Current Zoning: N1-A (neighborhood 1-A)
Proposed Zoning: R-8(CD) (residential, conditional)

Approximately 24.96 acres located on the south side of Allen Road East and east side of Citadel Place, west of Allen Road South.

The petition proposes a residential community of up to 84 single-family attached townhouse style dwelling units.

Staff recommends approval of this petition.

TITLE  
PRELIMINARY SITE PLAN  
R-8 (CD)  
RZP\_2023\_011

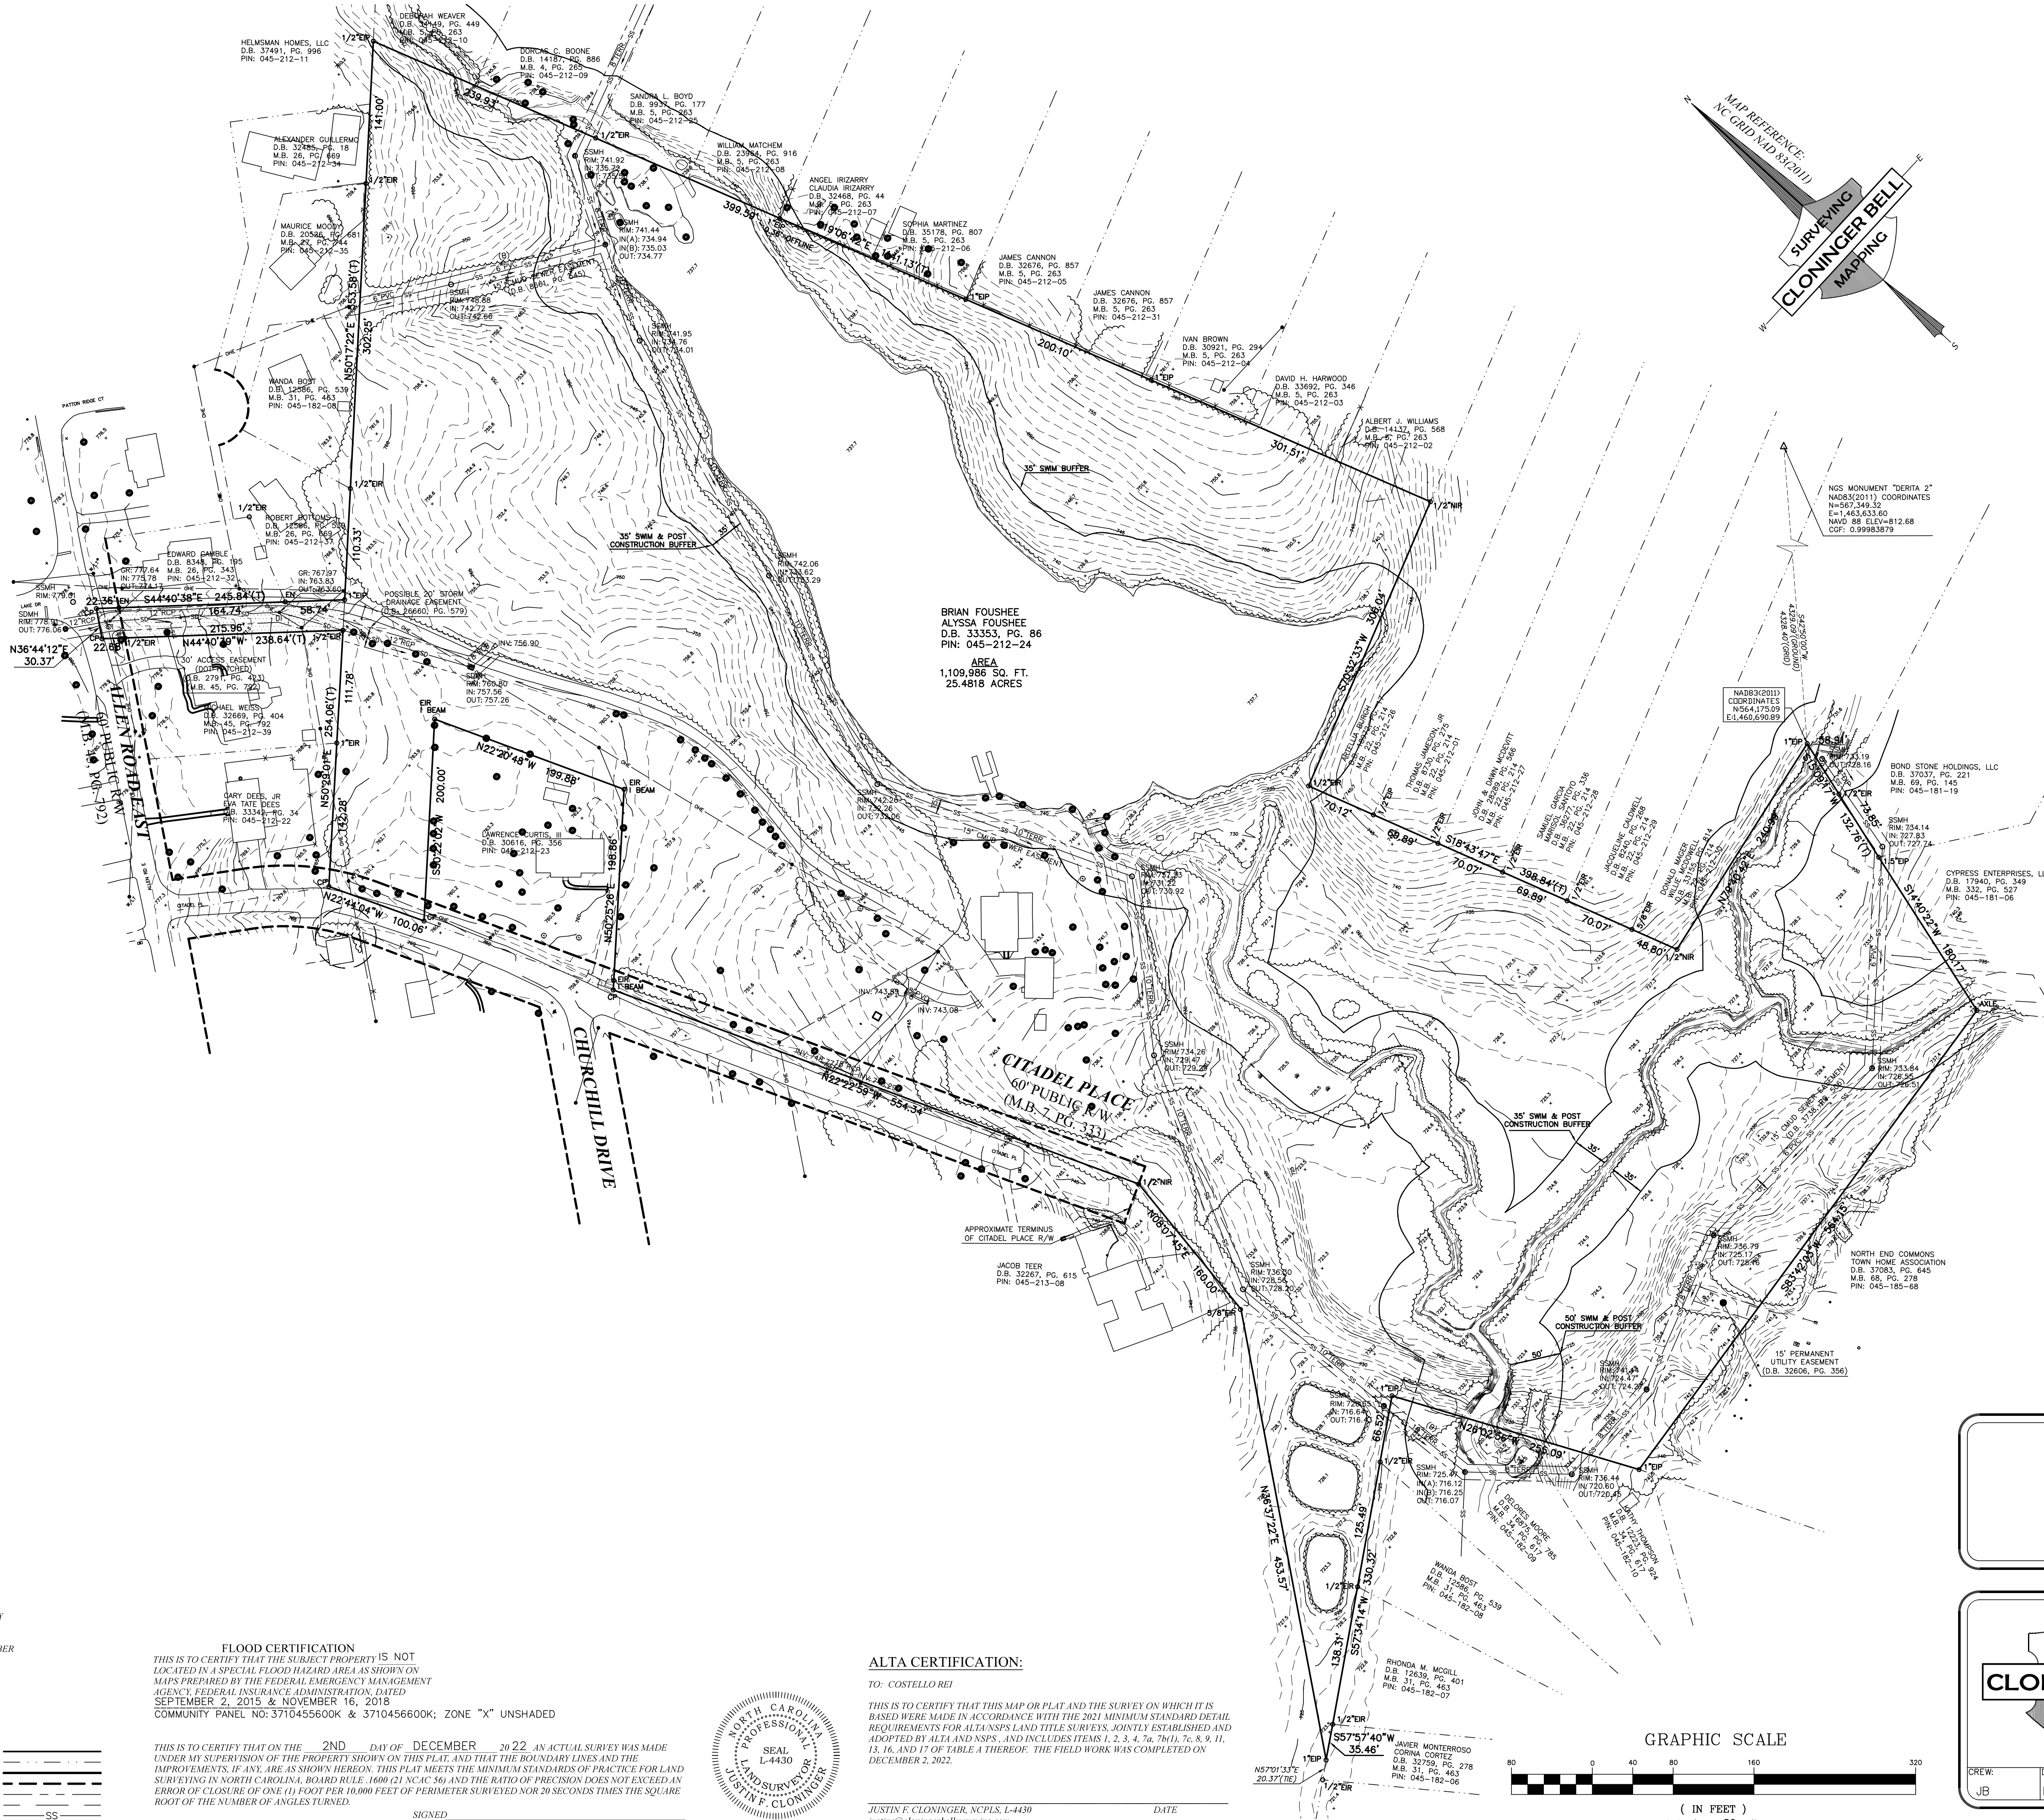
- ~~1. Reduce unit count and incorporate a mix of buildings that better align with the N1 Place Type (duplexes, triplexes).~~ Addressed
- ~~2. Relocate proposed dumpster location away from existing houses.~~ Addressed
- ~~3. Add visitor parking areas.~~ Addressed

- ~~4. Revise the park note to read: "land to be dedicated and conveyed to Mecklenburg County."~~ Addressed
